From: Jeff Watson
Sent: Friday, September 04, 2015 9:31 AM
To: 'Mahugh, Jim'
Cc: Gonseth, Paul; Holmstrom, Rick; Thorniley, Vicky; Christina Wollman; 'trevor@relevantplanning.com'; 'scottp@heathnorthwest.com'; kirstenh@heathnorthwest.com
Subject: RE: SI-15-00004 Pass Life Sign Permit

SI-15-00004 Pass Life

E01:FRONT VIEW FOOTING DETAIL  
SCALE: 1/2" = 1'-0"

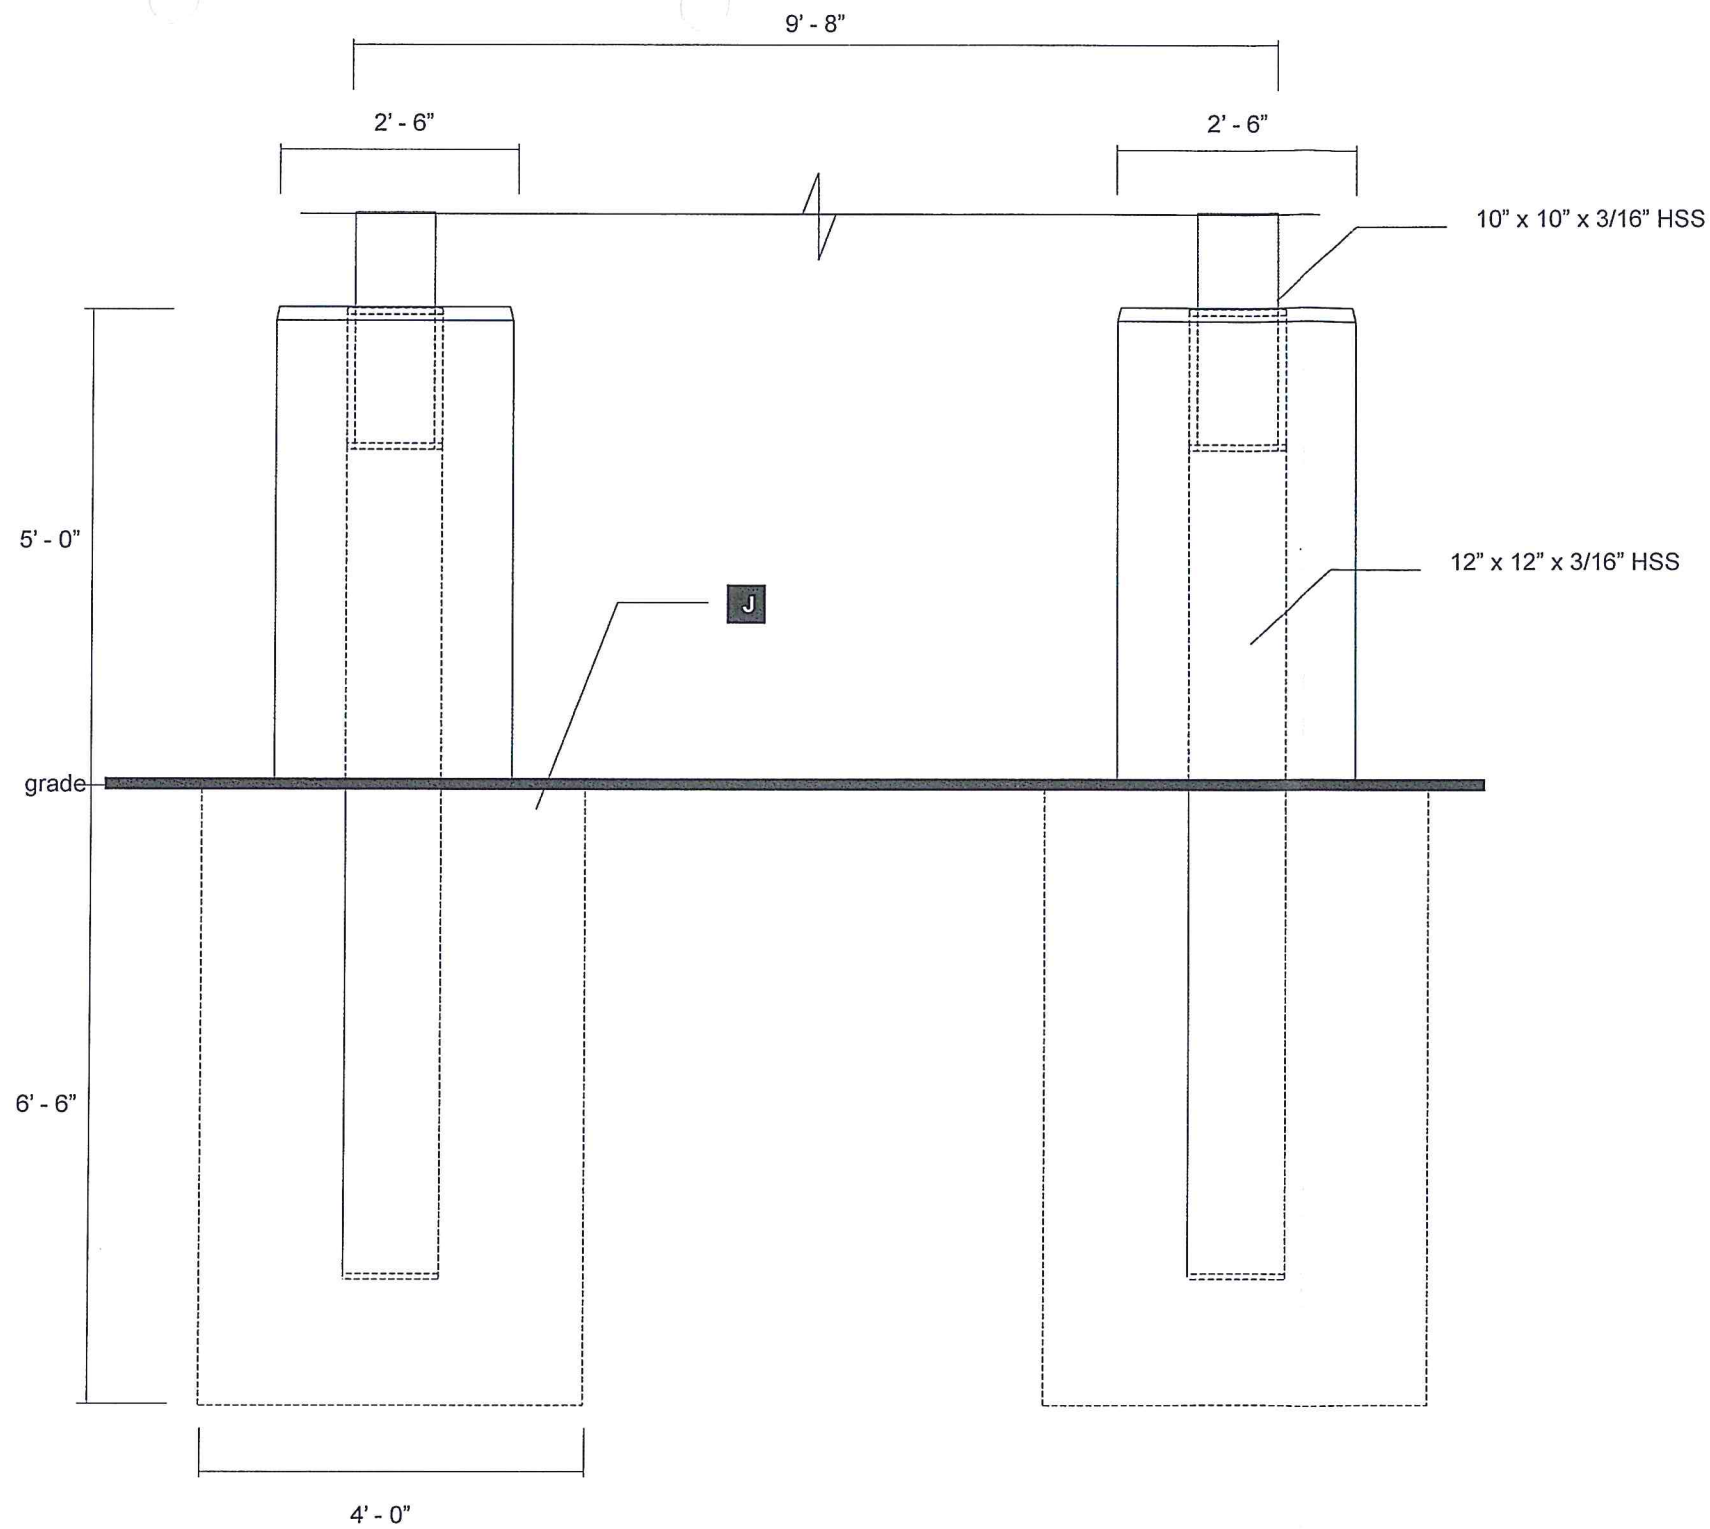
The WSDOT Traffic Office is responsible for overseeing compliance with the State Scenic Vistas Act. Rick Holmstrom has passed this signing issue on to me to comment. From the plans provided, the sign is 8' wide and approximately 20' tall. This equates to 160 sq ft. The Scenic Vistas act would classify this sign as a Type 3(b)(i) sign and these combination signs are limited to 150 sq ft including border and trim.

So this sign cannot be allowed per WAC 468-66-050 unless the size is under 150 sq ft. Please reflect that back to the developer and have them downsize the sign to fit within these requirements.
